KIRKLEES METROPOLITAN COUNCIL INVESTMENT & REGENERATION SERVICE

Reference No:	2023/62/92532/W
Site Address:	11, Town End Avenue, Wooldale, Holmfirth, HD9 1QW
Description:	Demolition of existing garage and erection of two storey extension and construction of single storey extension including external alterations including application of render to external walls
Recommending Officer:	Lucy Taylor

Officer Report.

Layout ID  
**C401-002**

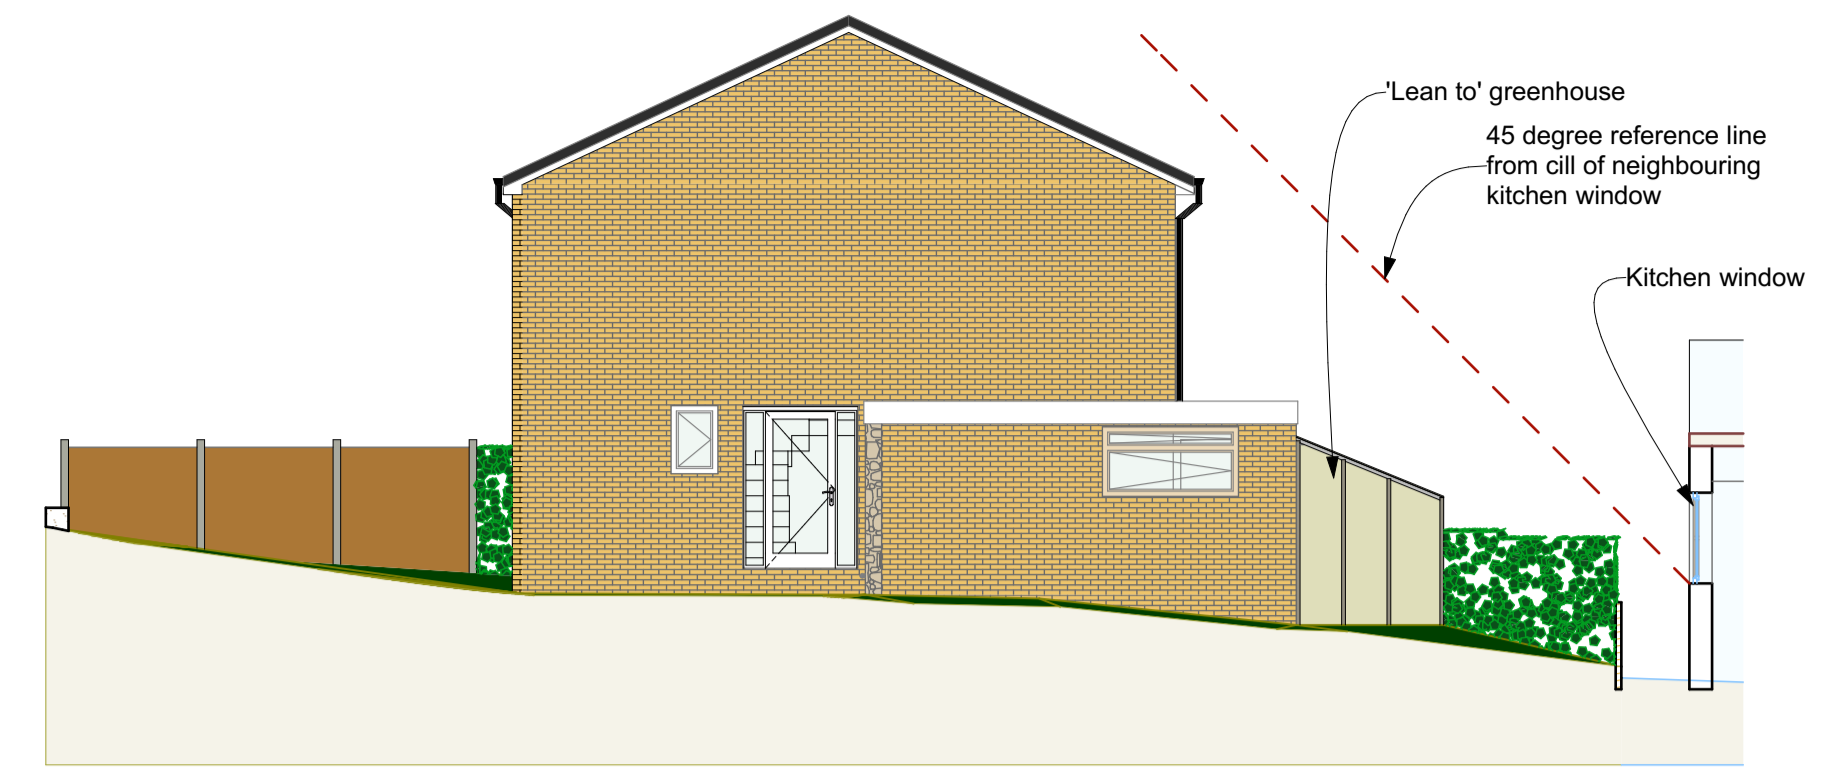
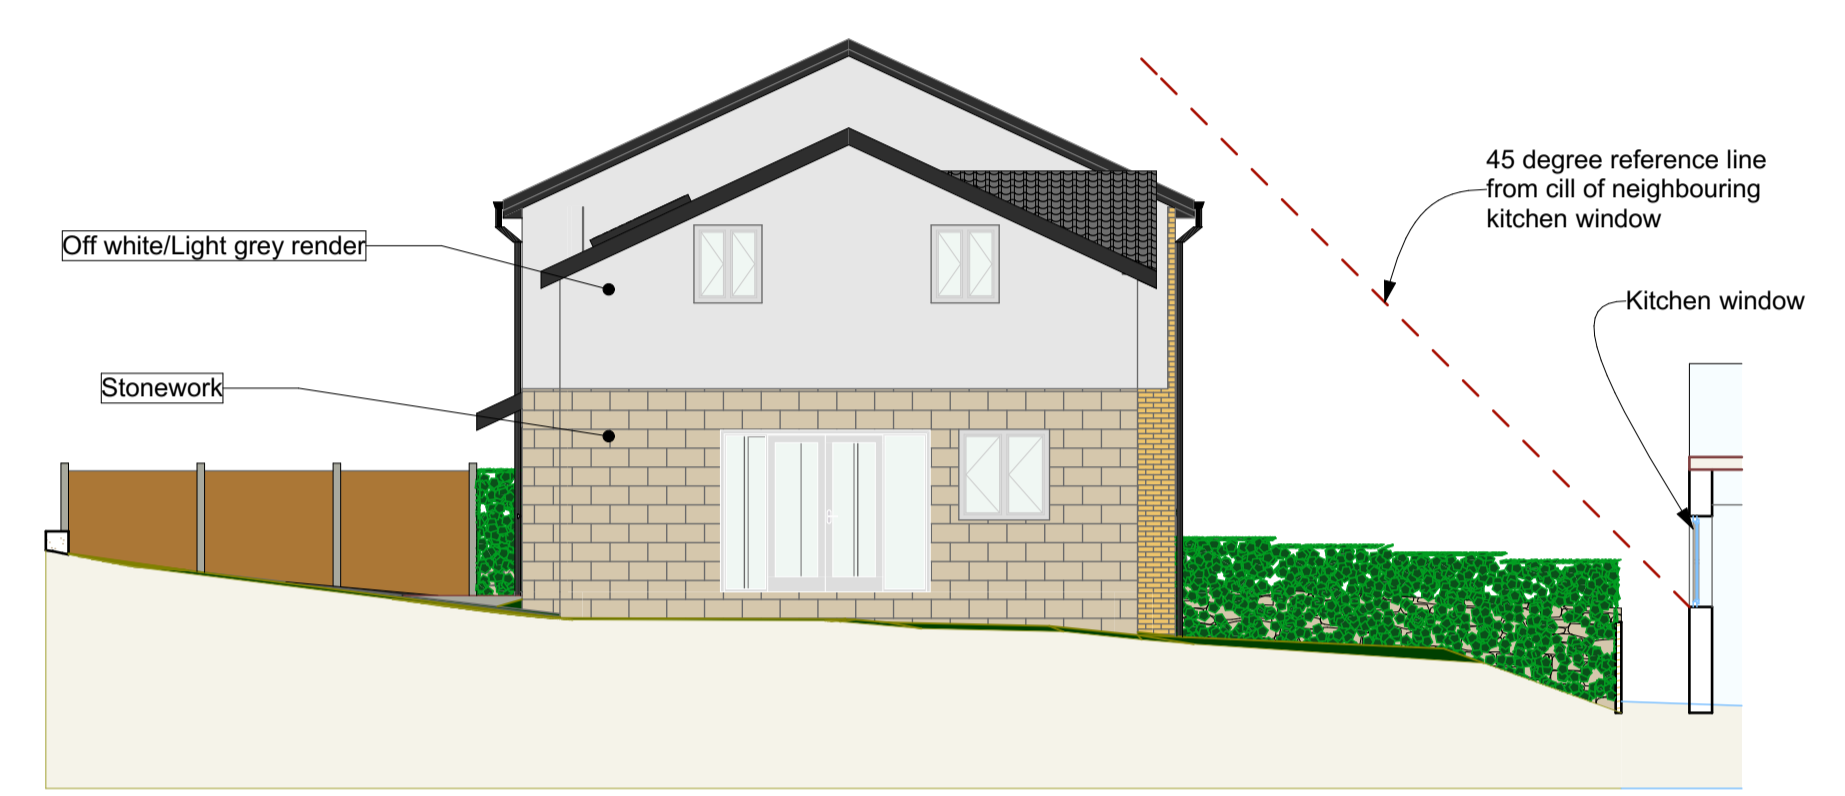
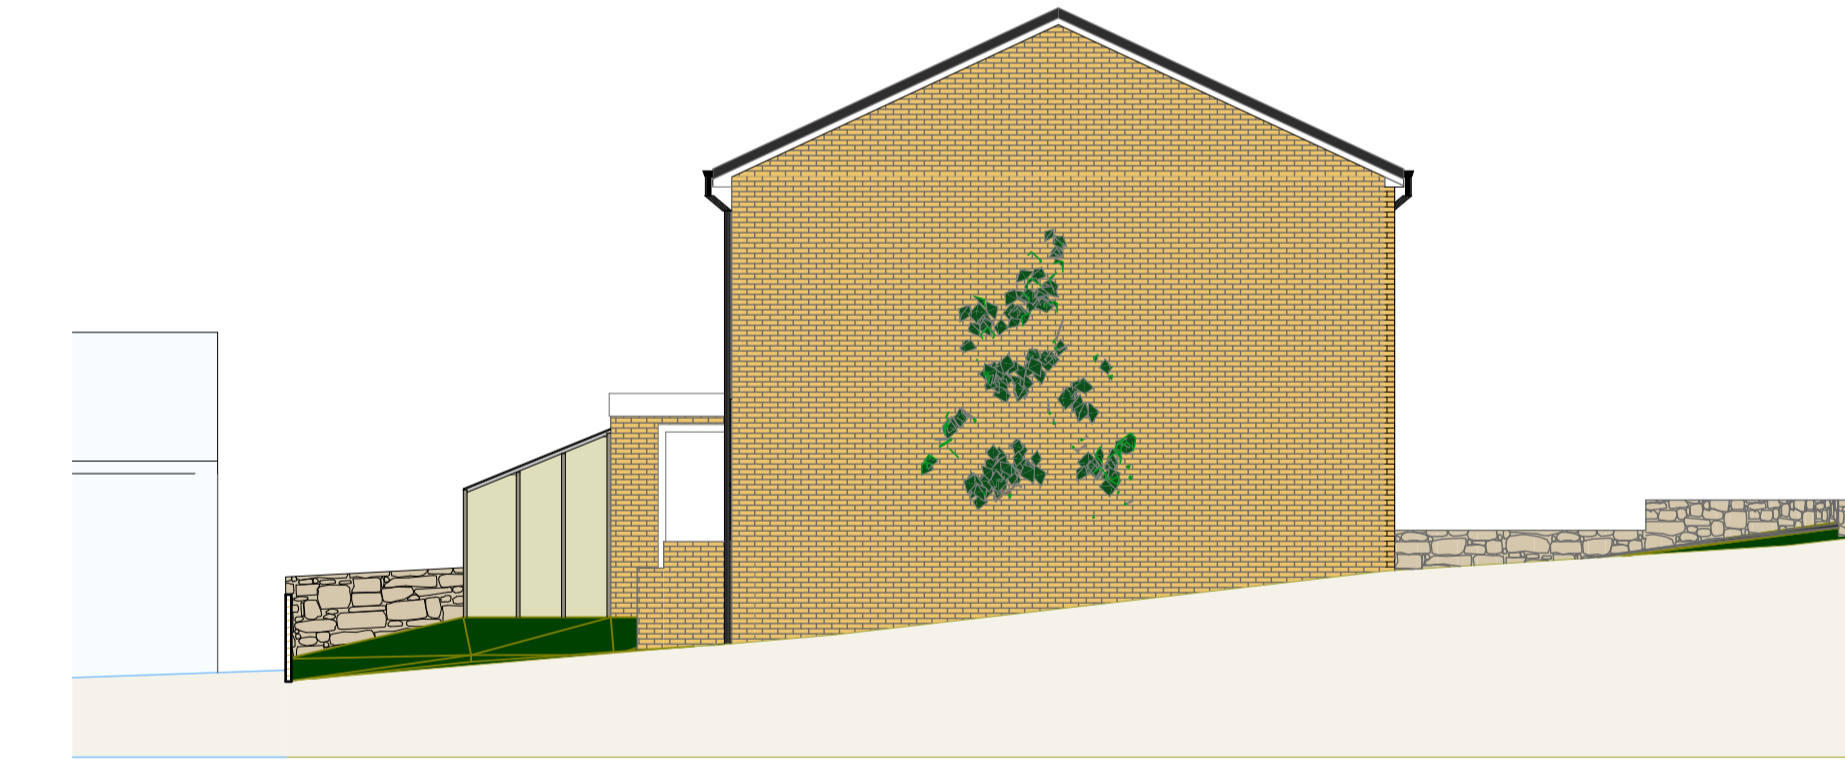
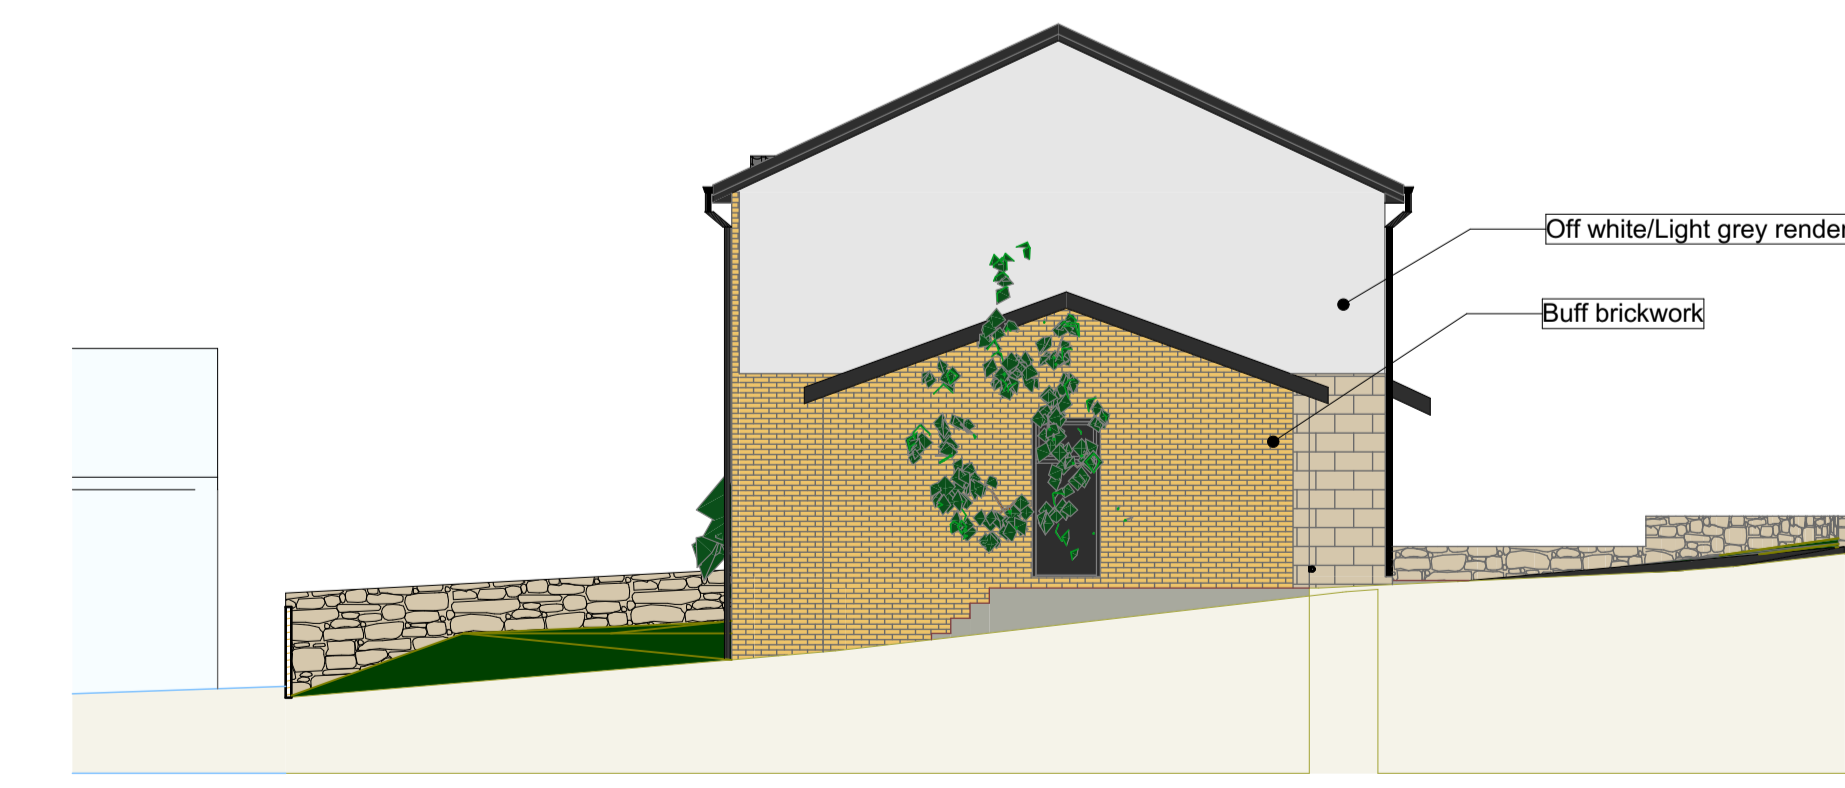
In accordance with the design principles of the House Extensions and Alterations SPD and for reasons of obtaining high standards of visual amenity and residential amenity, the case officer sought amendments to the originally proposed scheme. The extensions sought were as follows:

- Reduce the width of the proposed two-storey side extension so that it does not project beyond 2/3 of the width of the original house.
- Set the two-storey extension back 0.5 metres from the principal elevation of the original house.
- Reduce height of single storey side extension (garage) to 4 metres.
- Extent of render to principal elevation of original house remain as existing, to first floor only. Give consideration to reducing the extent of render to the proposed two-storey side extension.
- Give consideration to moving the 1st floor rear window to the side elevation of the two-storey extension.

Both extensions would be faced in materials that are in keeping with the architectural design of the host property (buff brick, stonework and render). Upon any grant of approval, a condition would be imposed to ensure that the render be coloured off-white rather than light grey, to ensure its application does not disrupt the existing character of the streetscene. The roofs of the extensions would be infilled with matching concrete tiles.

4. The proposed render to the exterior walls of the host dwelling and extensions shall be of an off-white colour to harmonise with the existing stonework and the design of render to other properties within the streetscene.
